File reference	TR040011
Status	Final
Author	The Planning Inspectorate
Date	25 June 2019
Meeting with	North Somerset Council and Womble Bond Dickinson (The Applicant)
Venue	WBD Office
Meeting objectives	Draft documents and submission
Circulation	All attendees

The Portishead Branch Line (MetroWest Phase 1) Order

Section 51 Advice – draft Application Documents provided by North Somerset District Council for The Planning Inspectorate’s (The Inspectorate’s) review

Drawing :
**Habitat Impacted by Construction Works
within the Avon Gorge Woodlands SAC
APFP Regulation 5(2)(a) and 5(2)(o)**

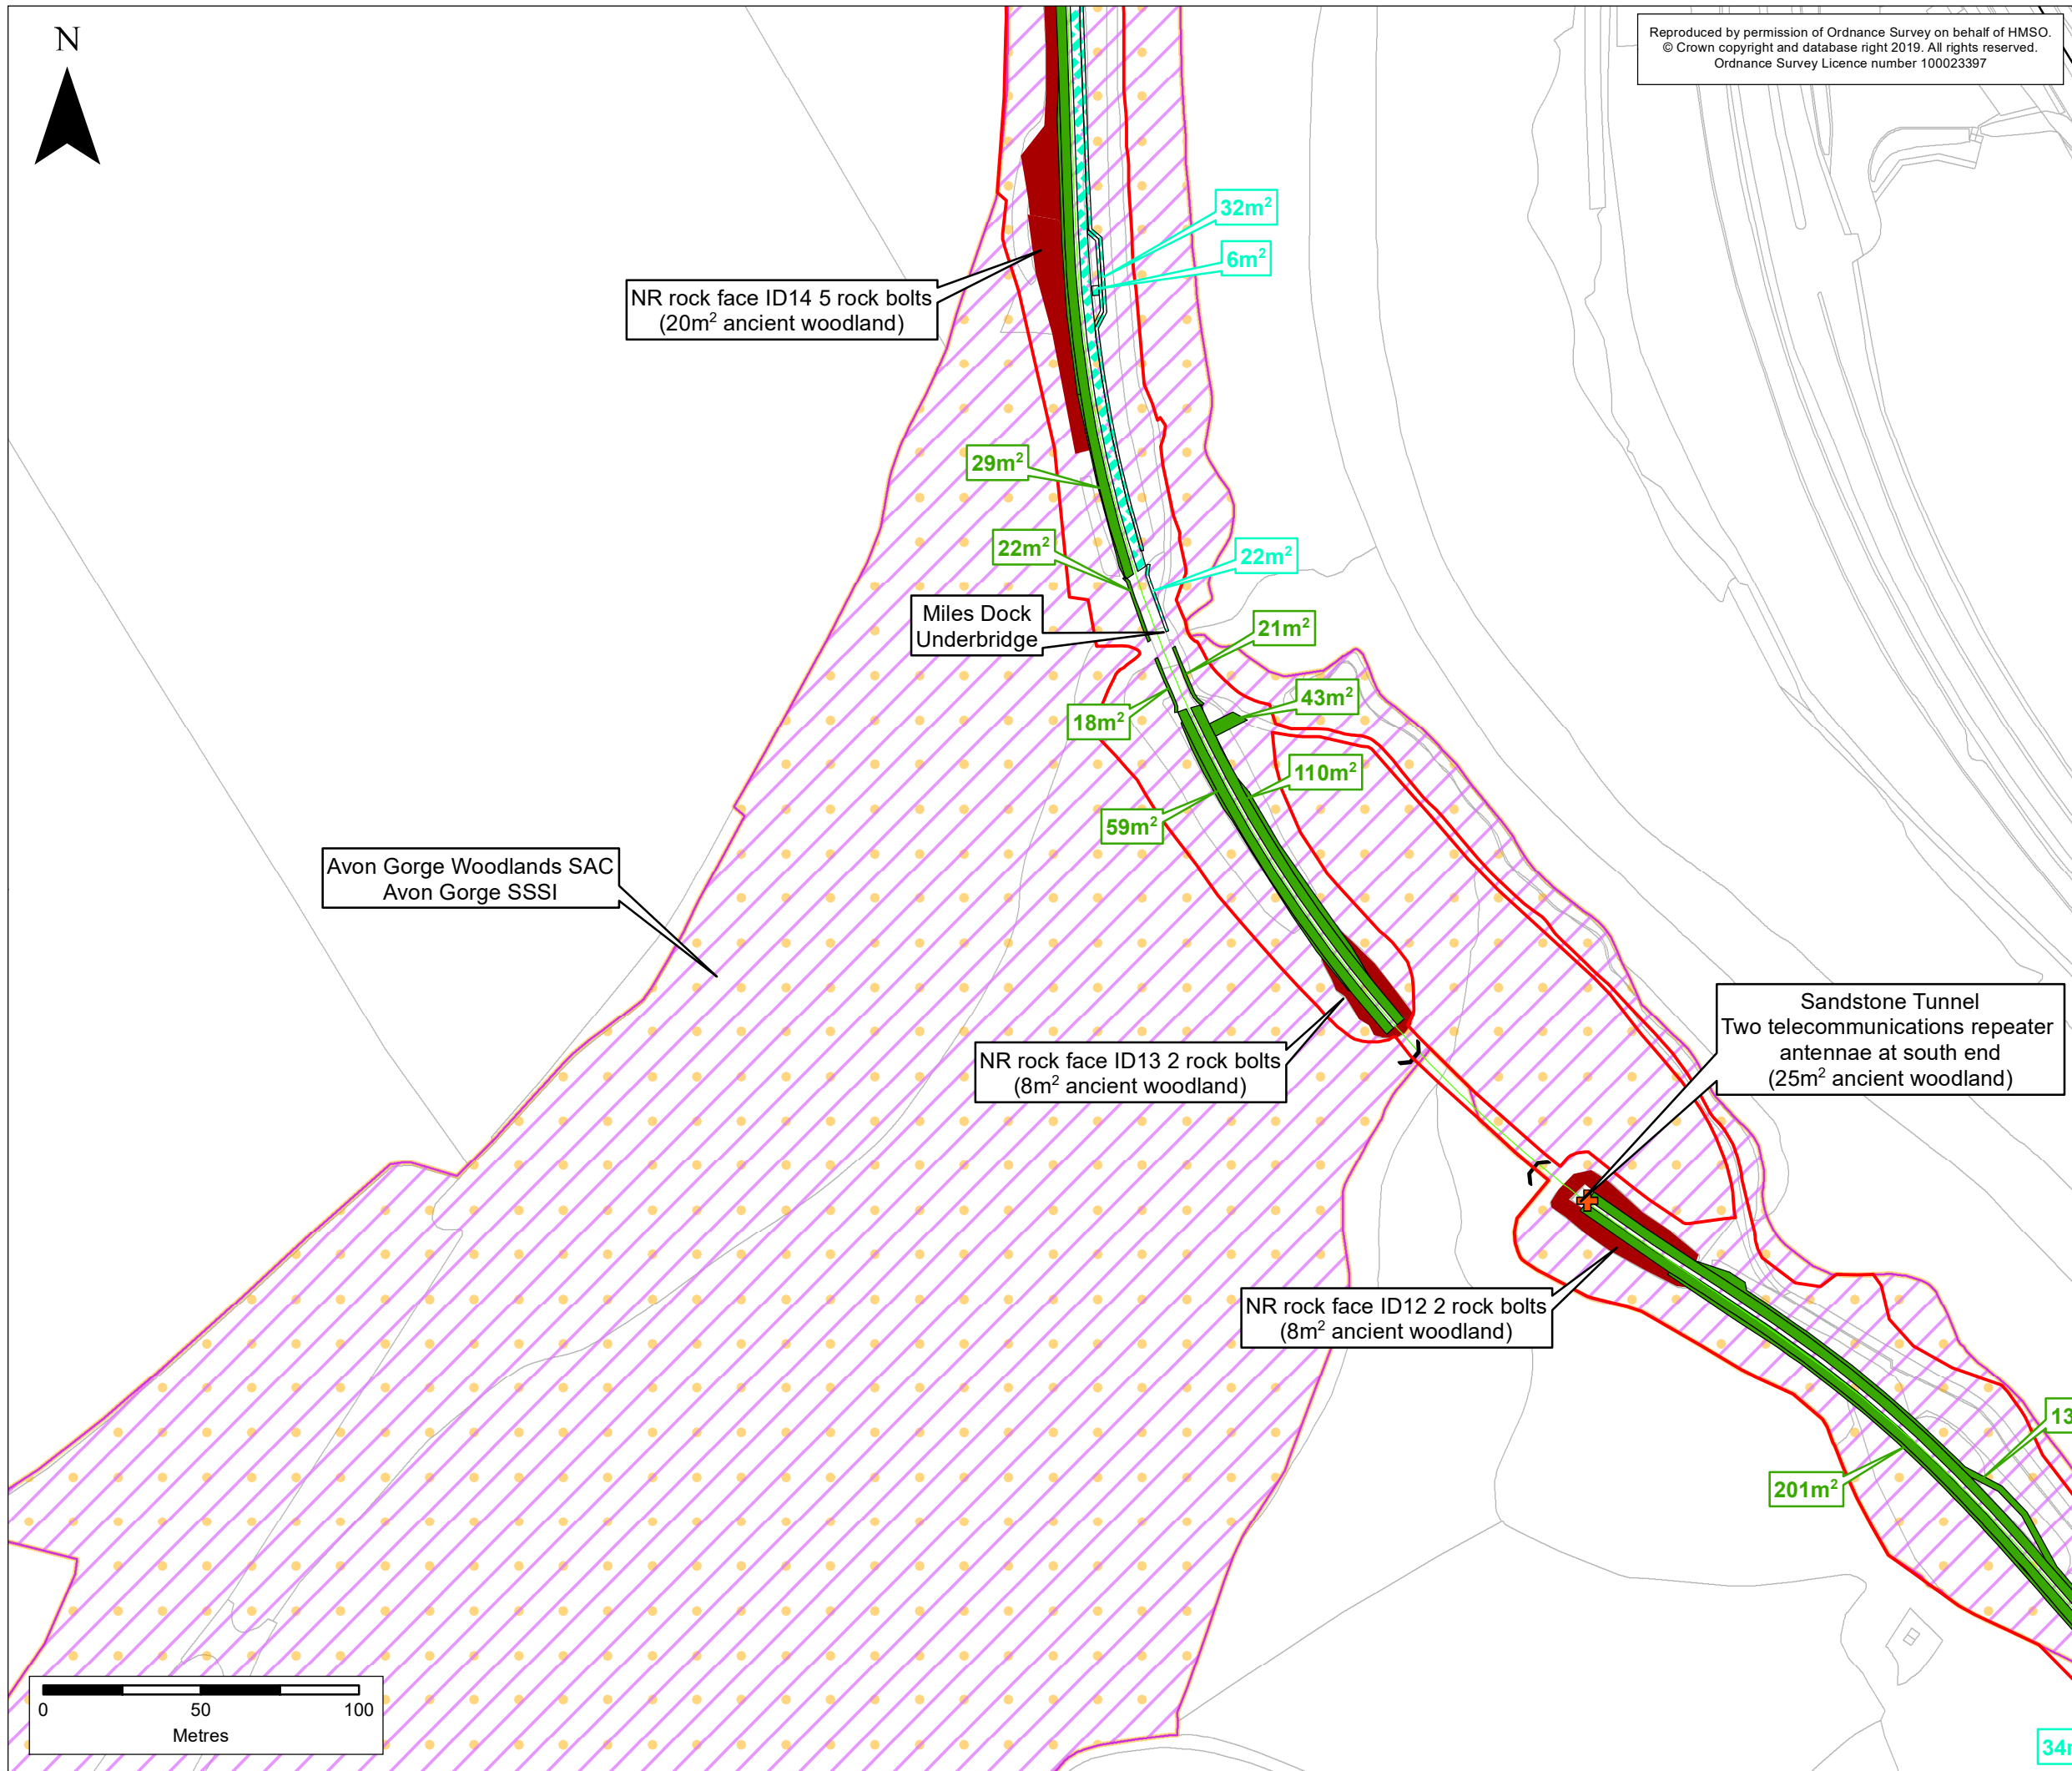
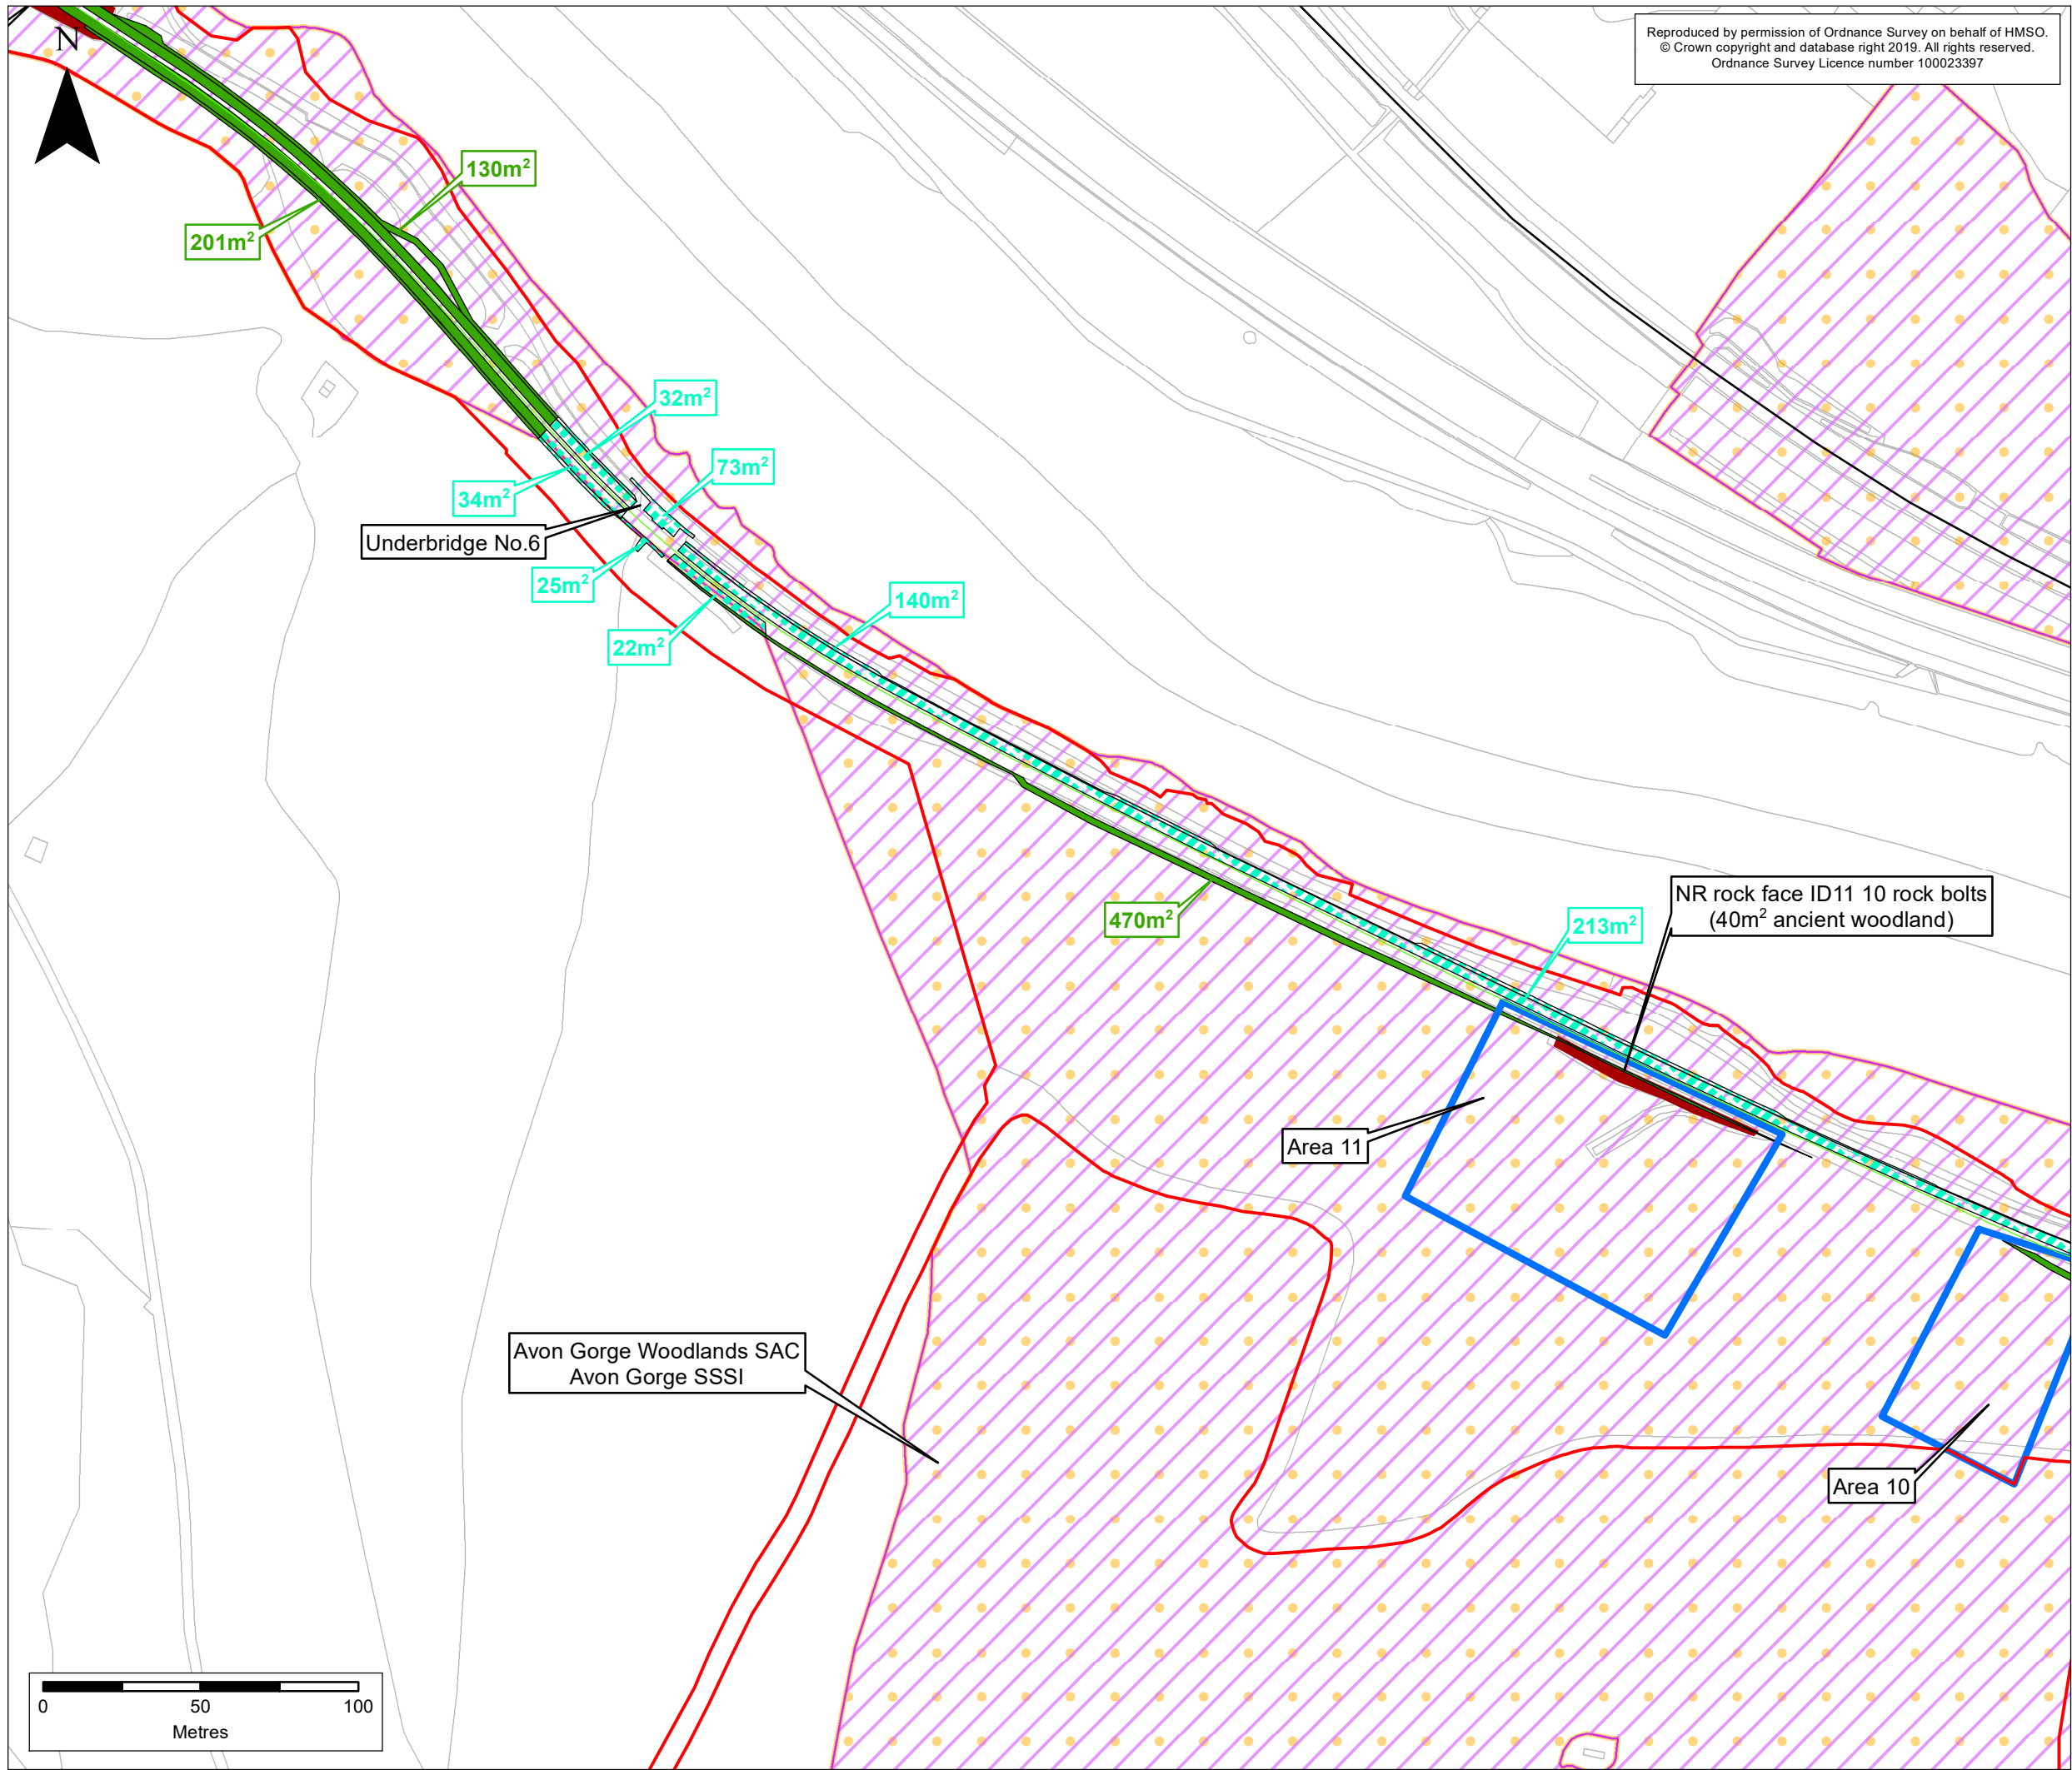
3.	Executive summary, 4.2.3	Areas of habitat loss	The text would benefit from stating %loss figures as well as actual hectarage loss. It is unclear whether the HRA includes the area of habitat loss on the cliff face within the total. This should be included.

14.	Table 5.1	BCC - definition of extent of vegetation removal and definition of limit of the works.	The HRA describes the extent of vegetation removal but it would help to illustrate the extent of this removal on a plan.
